DEPARTMENT OF THE AIR FORCE
10TH CIVIL ENGINEER SQUADRON
USAF ACADEMY COLORADO

Subject: USAFA's review of the proposed Urban Landing PUDSP development (File no. PUDSP243)

URBAN LANDING
PRELIMINARY PLAN
PRELIMINARY DRAINAGE REPORT
PRE-DEVELOPMENT MAP

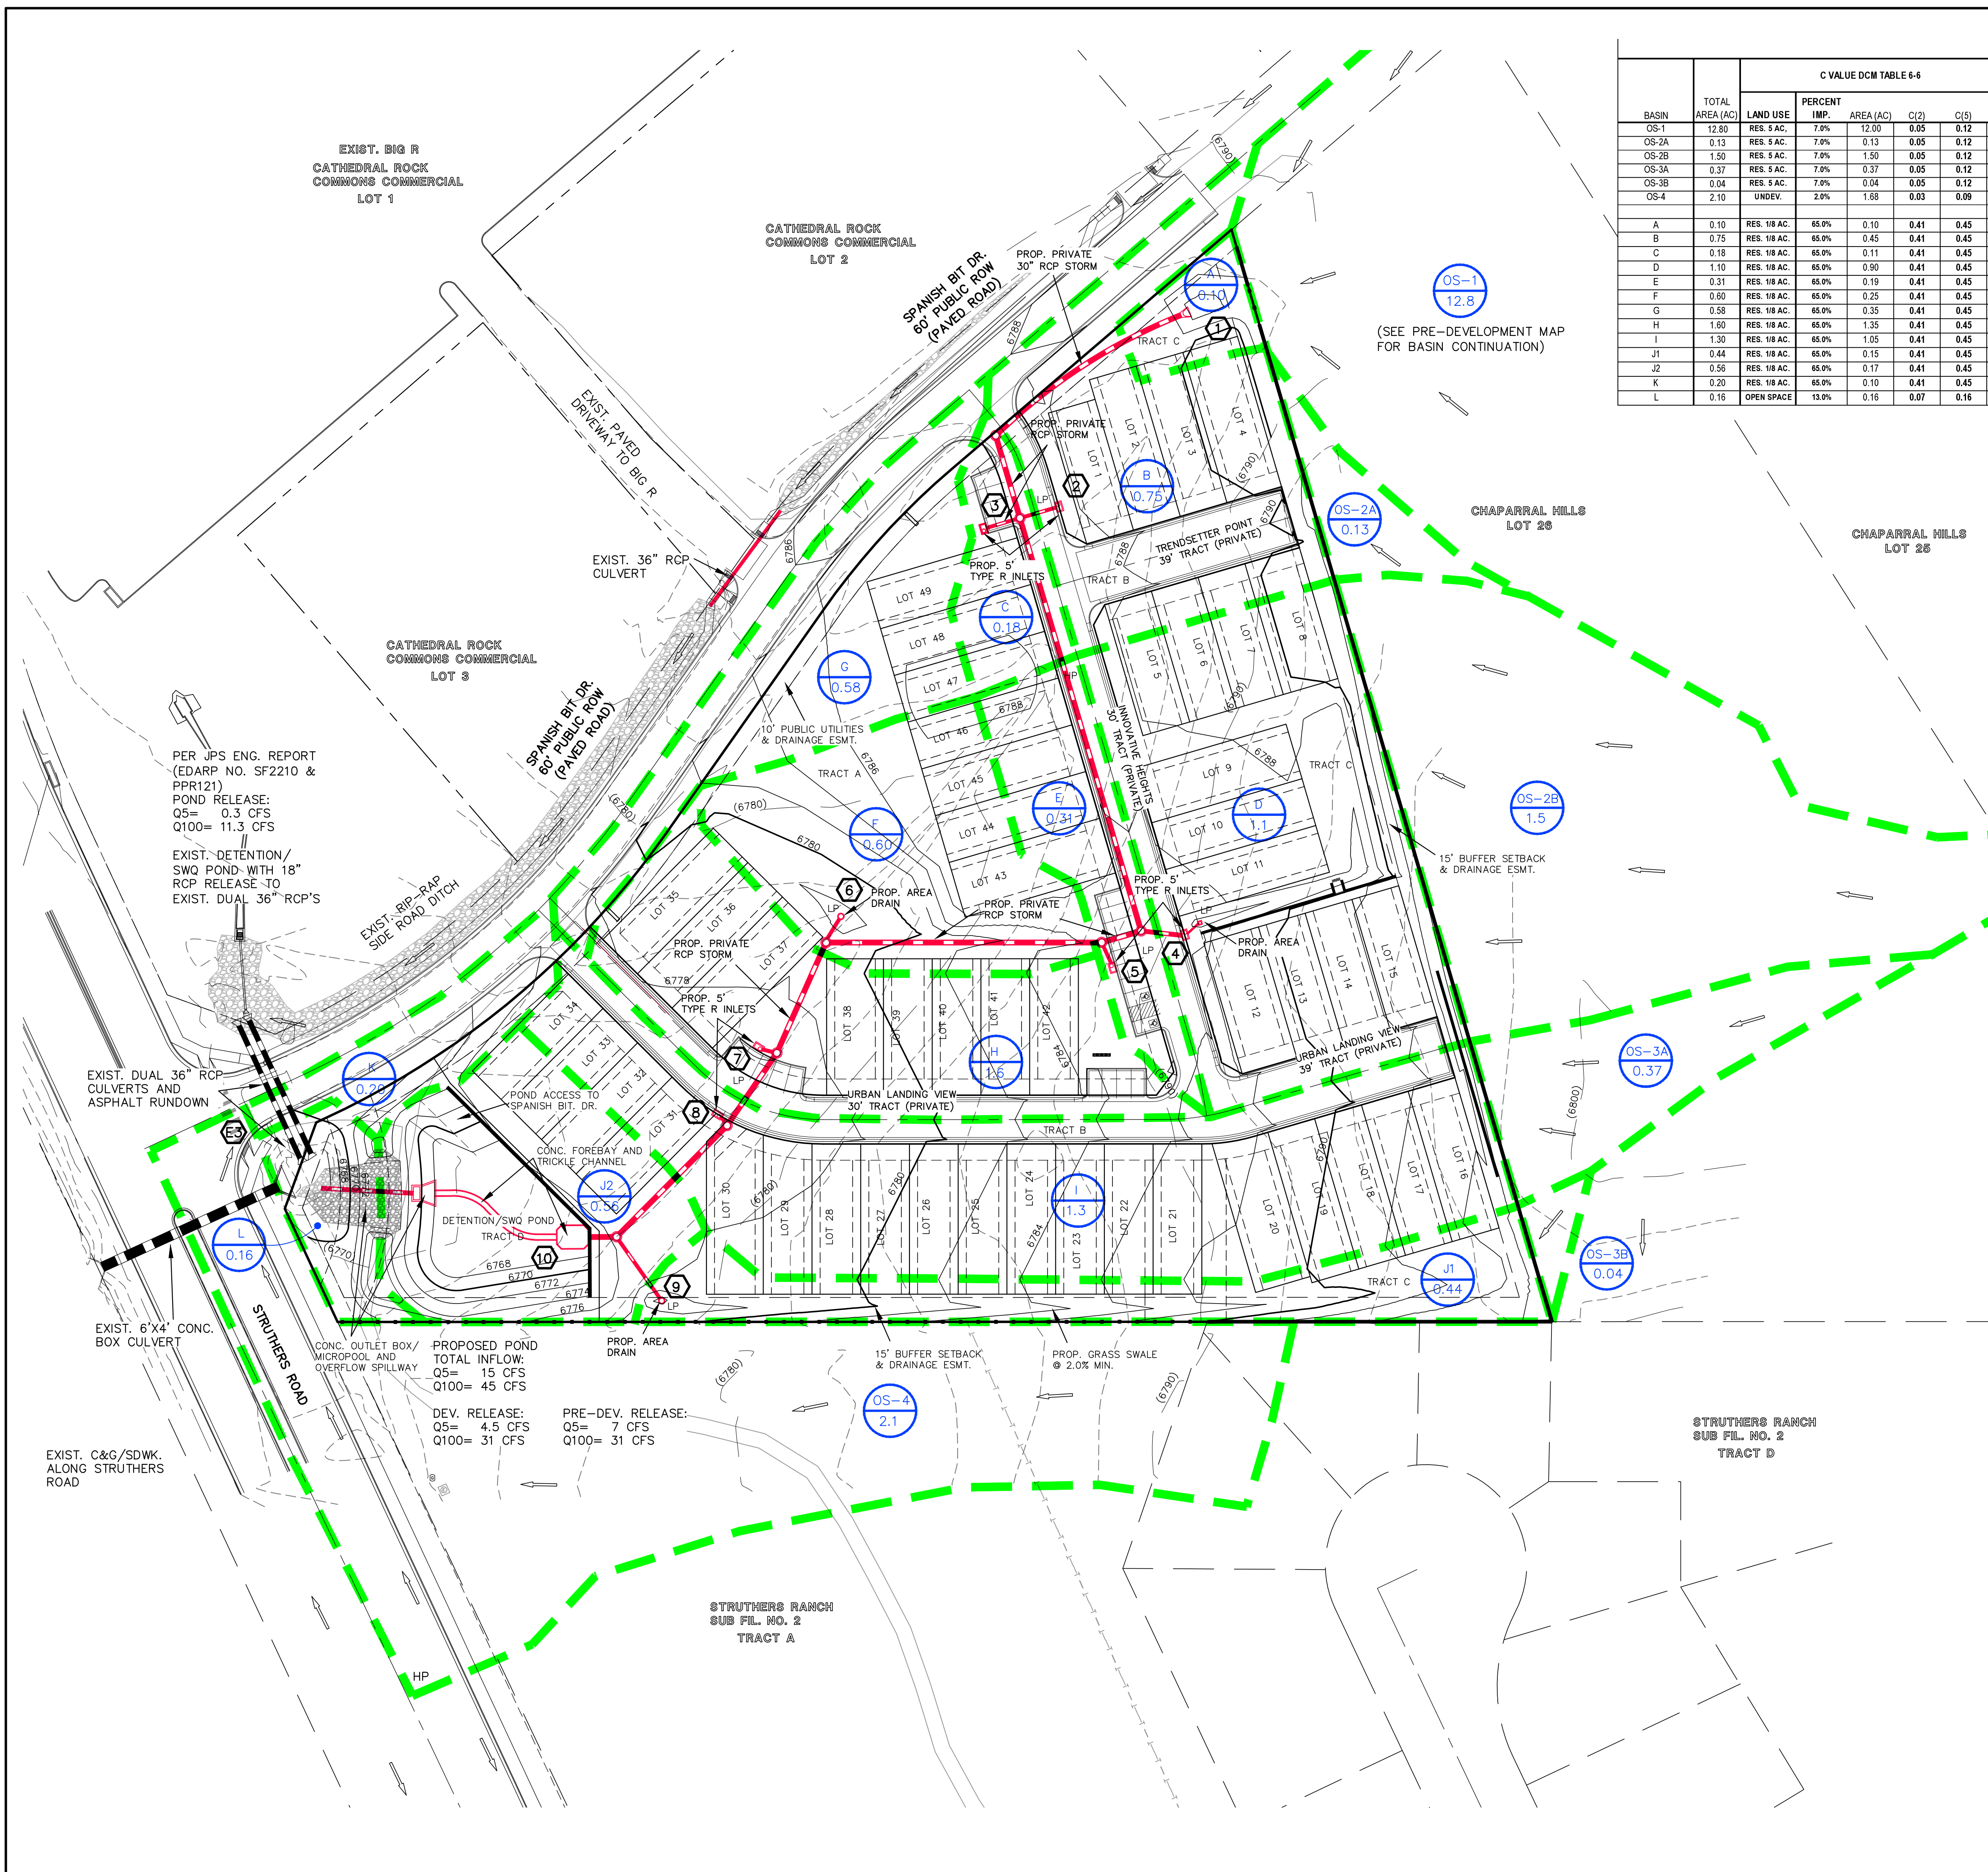
Upon closer review of the drainage report, USAFA believes that the stormwater analysis and proposed solutions has inaccuracies. Fundamentally, USAFA disagrees that stormwater from the proposed Urban Landscape project will be discharged into Jackson Creek. Based on our review of maps and the site itself, the stormwater will be discharged into an unnamed intermittent streambed between Jackson Creek and Black Forest Creek, which will eventually discharge directly to Monument Creek. Historically, this intermittent streambed rarely receives sufficient volume of stormwater runoff to discharge into Monument Creek. Unfortunately, this proposed development will drastically increase the volume of water into this unnamed intermittent stream channel. This increased volume will significantly change the hydrology of the area and cause moderate to severe damage to neighboring properties, including USAFA's property, before discharging into Monument Creek. Examples of possible damage from elevated water volumes include, but are not limited to, headwall cutting, disconnecting the

Once the stormwater from the proposed development leaves the property, it will travel through multiple properties and jurisdictions before reaching Monument Creek. From the Urban Landing property, the stormwater will cross under I-25, Colorado Department of Transportation controlled land, the Falcon Commerce Center property in the Town of Monument, over El Paso County Parks Department's Santa Fe Trail, onto the United States Air Force Academy's property, under the Union Pacific/BNSF's rail tracks and land. The water then goes back onto USAFA's land and drains into a wetland that is prime habitat for the federally protected Preble's Meadow Jumping Mouse, before emptying into the already-incised Monument Creek, which is also protected habitat for the threatened Mouse. No part of this intermittent streambed is prepared for the additional volume of water that will come from the proposed development.

Per the Urban Landing's Preliminary Drainage Report, there are no proposed improvements outside of its property boundary. According to the County's Stormwater Drainage Criteria Manual Volume 2, Chapter 4.1, step two of the Four-Step process discusses stabilization of natural drainages adjacent to new development. Downstream properties should not have to bear the burden of additional water volume and associated adverse impacts (increased sediment deposition, riparian habitat degradation, head-cutting, disconnection to the floodplain, increased safety concerns, etc.) on their properties from upstream development. Additionally, the cost of rehabilitating impacted riparian habitat that hosts a threatened species will necessitate significantly more mitigation than is currently addressed in the original design plan. Repairing stormwater-damaged streams on USAFA since 2007, has cost \$15 million, which equates to approximately \$1 million per acre to restore Preble's Meadow Jumping Mouse habitat.

- Notify all downstream property owners and jurisdictions (listed above) and request that they comment once an updated drainage report is available.
- Request that the developer address all flow rates and volumes on the property consistent with Drainage Criteria Manual Volume 1 and stabilize downstream waterways.
- Attend a site visit with USAFA staff to see and discuss the proposed development area.
